**From:** Amanda Scholes on behalf of Planning.Responses  
**Sent:** 01 June 2018 09:38  
**To:** Planning Scanning  
**Subject:** FW: FG/64/18/DOC - Compliance with condition 5

**From:** Ian Hayward [<mailto:ian.hayward@westsussex.gov.uk>]  
**Sent:** 31 May 2018 12:12  
**To:** Anita Gardner  
**Subject:** RE: FG/64/18/DOC - Compliance with condition 5

- 5 Prior to the commencement of development details of the proposed traffic light system to control access in and out of the site shall be submitted to and approved by the local planning authority. This should include the:

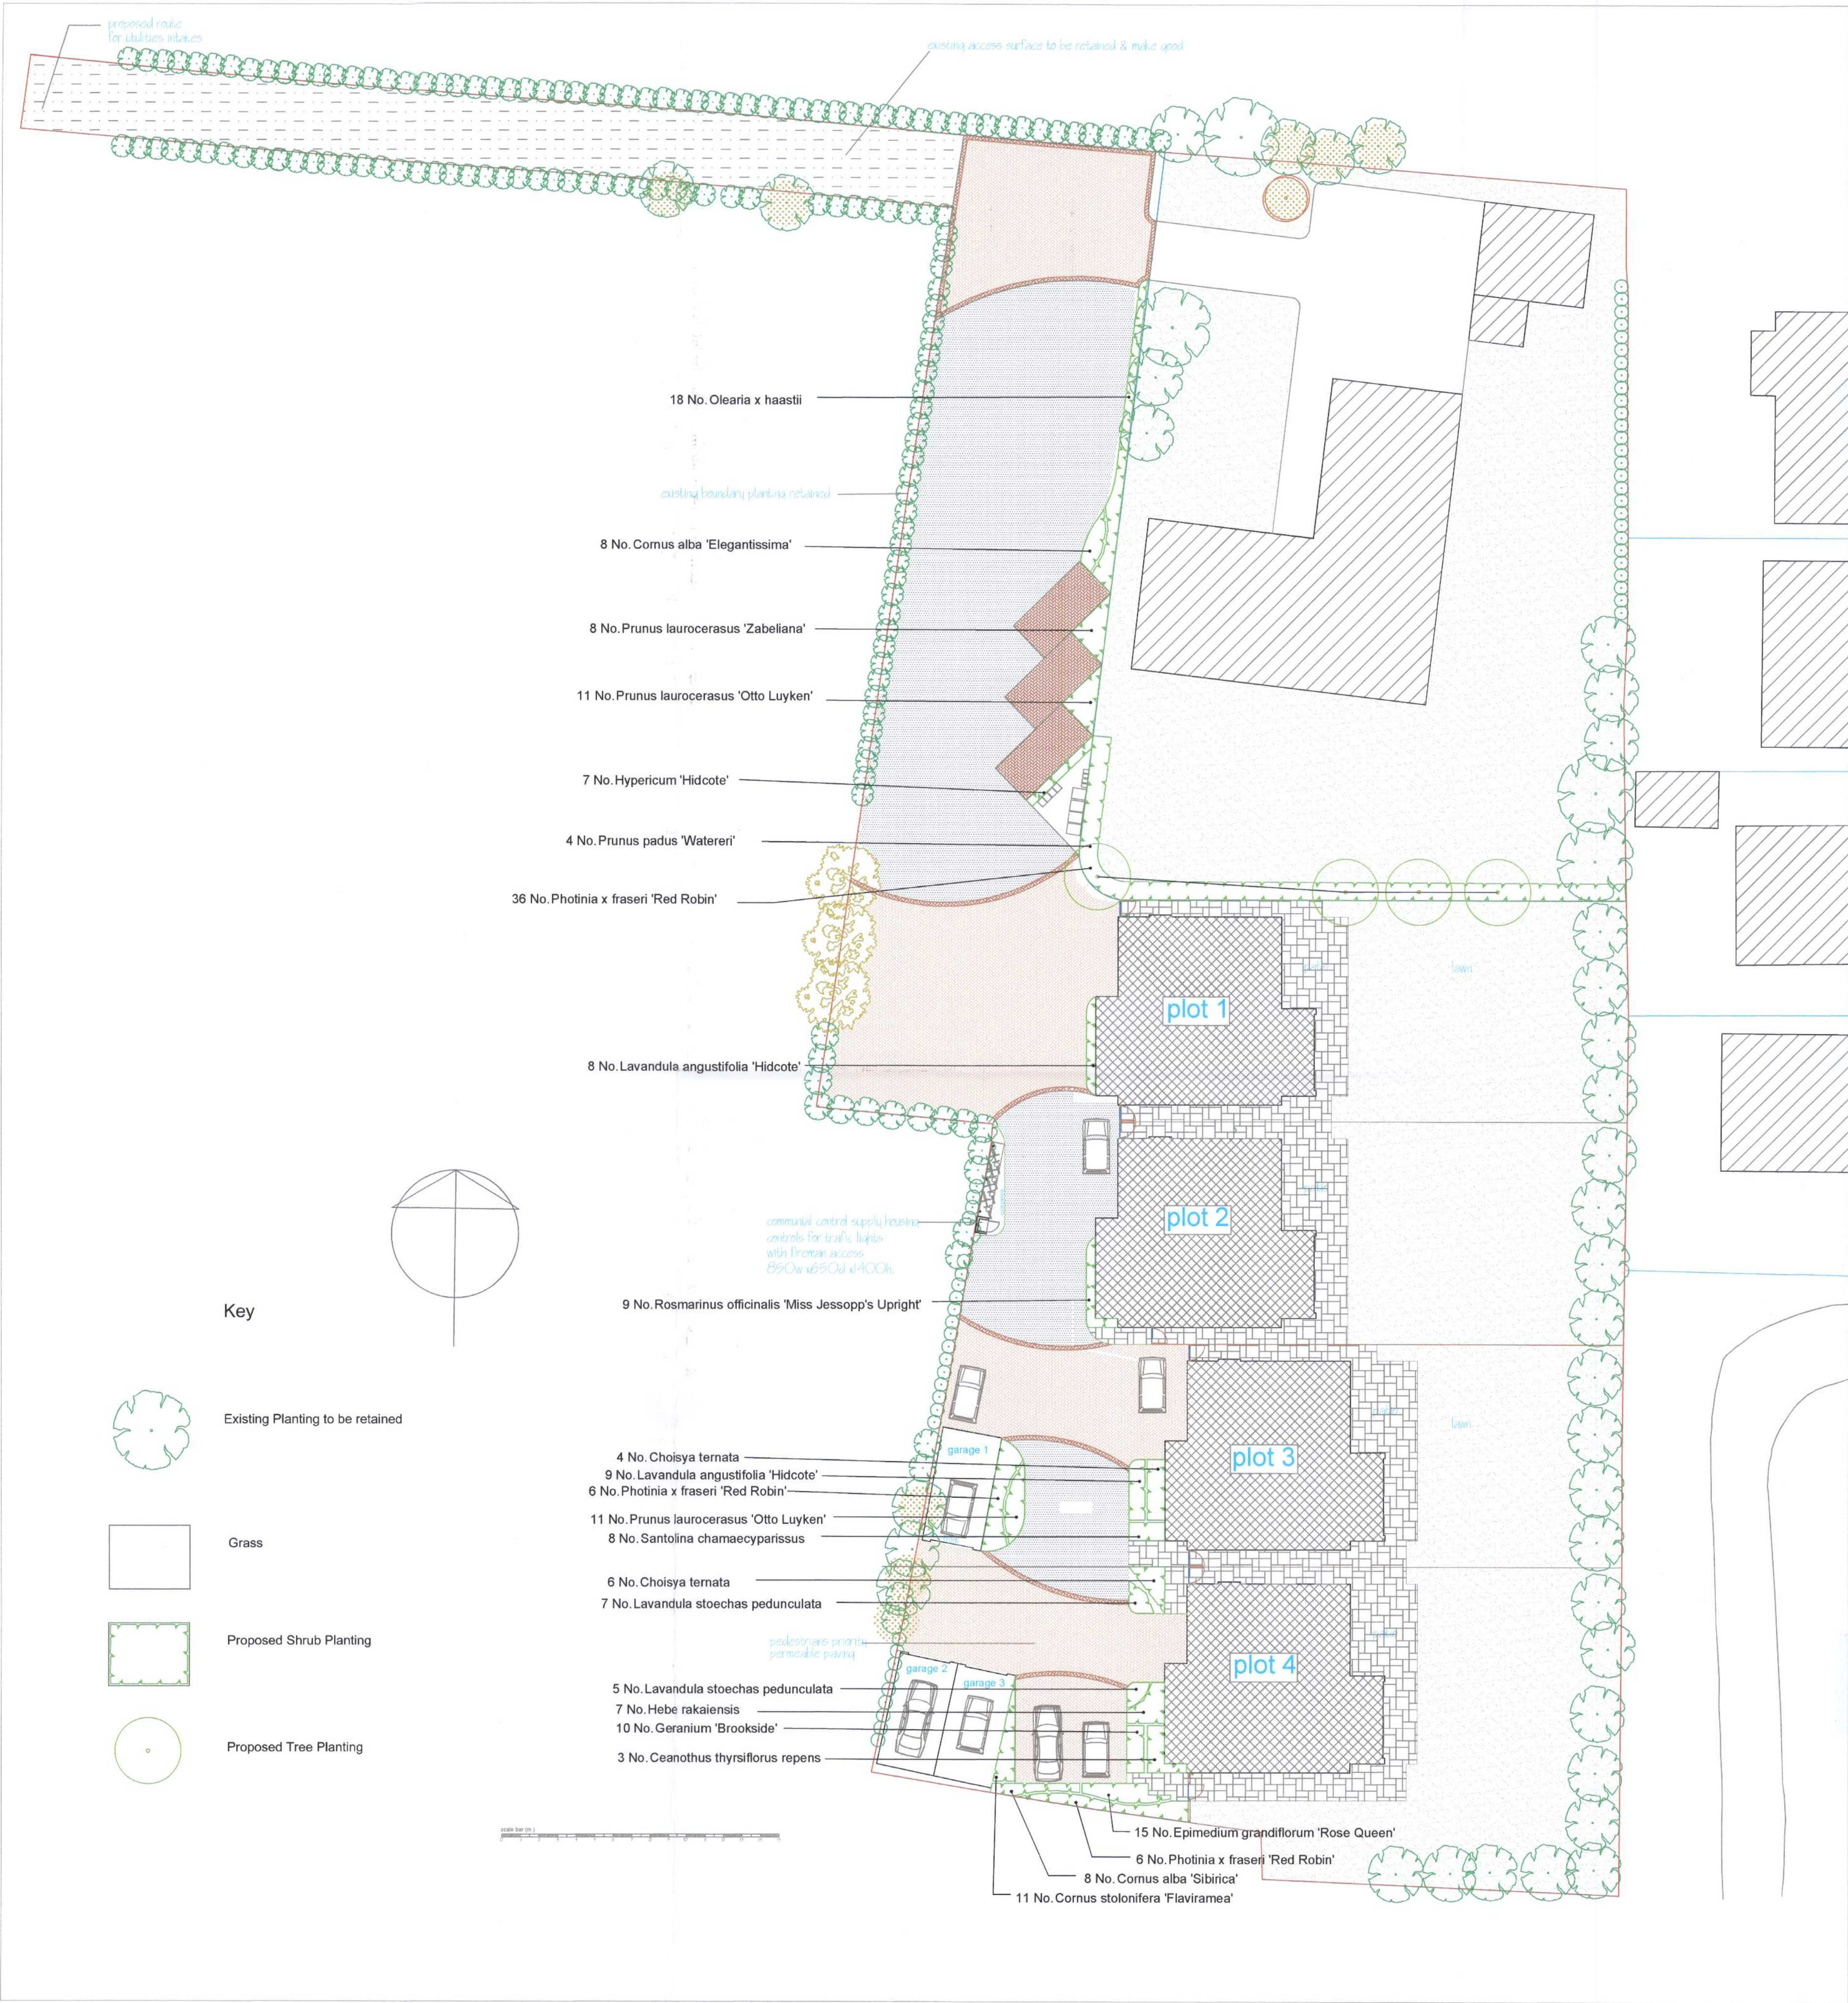
*I would particularly note the area at the foot of my garden that has always been previously shown on plans as a green area to be retained where access road enters the plot and curves round to the right now looking like hard standing?*

**Only four medium trees on a site of this size is what one would expect of inner city housing estates.**

*It is not clear if the trees and shrubs will be within the garden of 44 or that of plot 1?*

**The landscaping plans do not show any planting to restore privacy to the surrounding neighbours' properties lost by prior removal of virtually every tree on the site, and now substituted with what appears to be two tone hardstanding from north to south bar small rear lawns of the new houses that border their boundaries.**
